COUNCIL ADVICE

Pre- EIS – SSD CONSULTATION

PROPERTY:	15-21 Cottonwood Crescent, Macquarie Park	
MEETING DATE:	29 January 2026	TIME: 10:00am
COUNCIL REFERENCE:	PRL2025/60	
DEVELOPMENT:	State Significant Development Application and concurrent rezoning to allow higher density residential development.

Figure 19 Extract of proposed plans: Lower Ground Floor (DA2007).

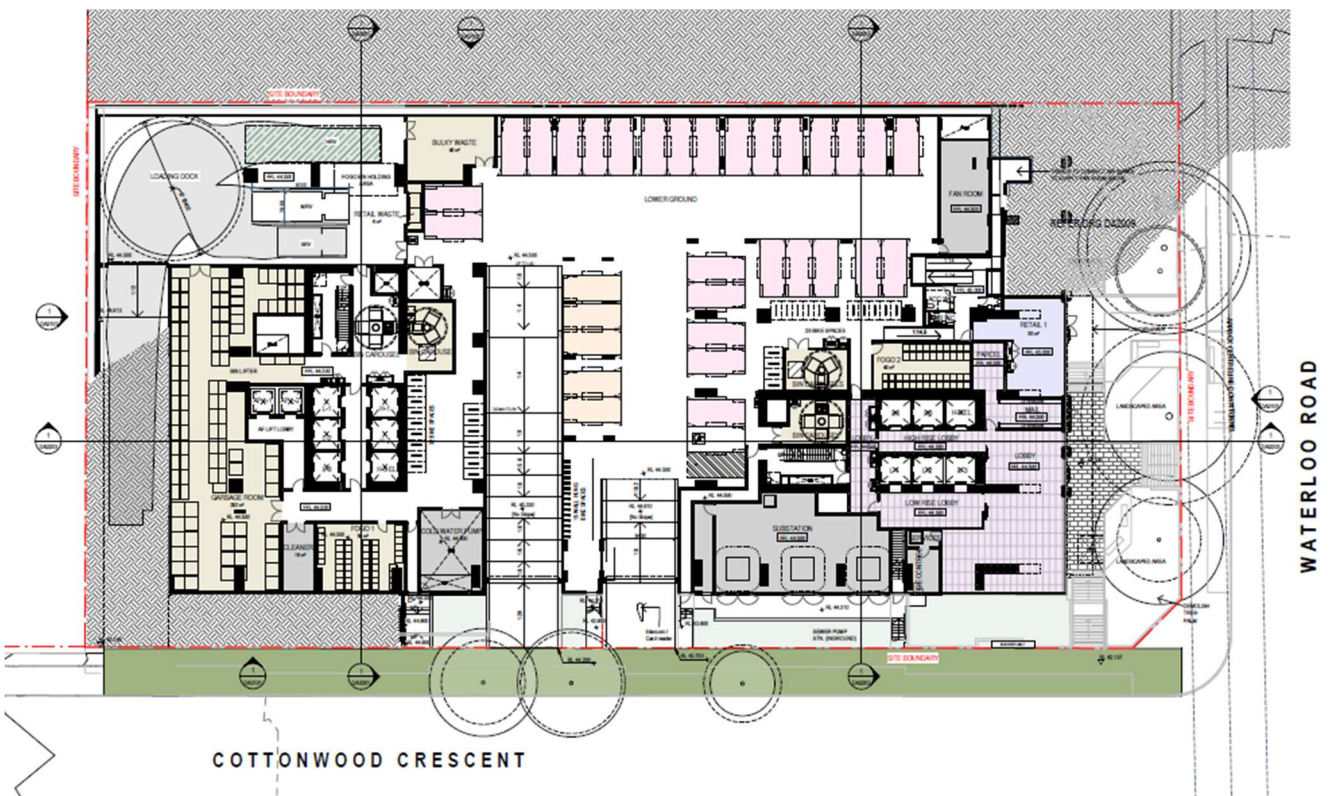
The increase in density has resulted in the proposal showing 3 separate vehicular access points to the site. The presence of two vehicle access points and one loading dock along Cottonwood Crescent poses additional risks to pedestrian movement and safety.
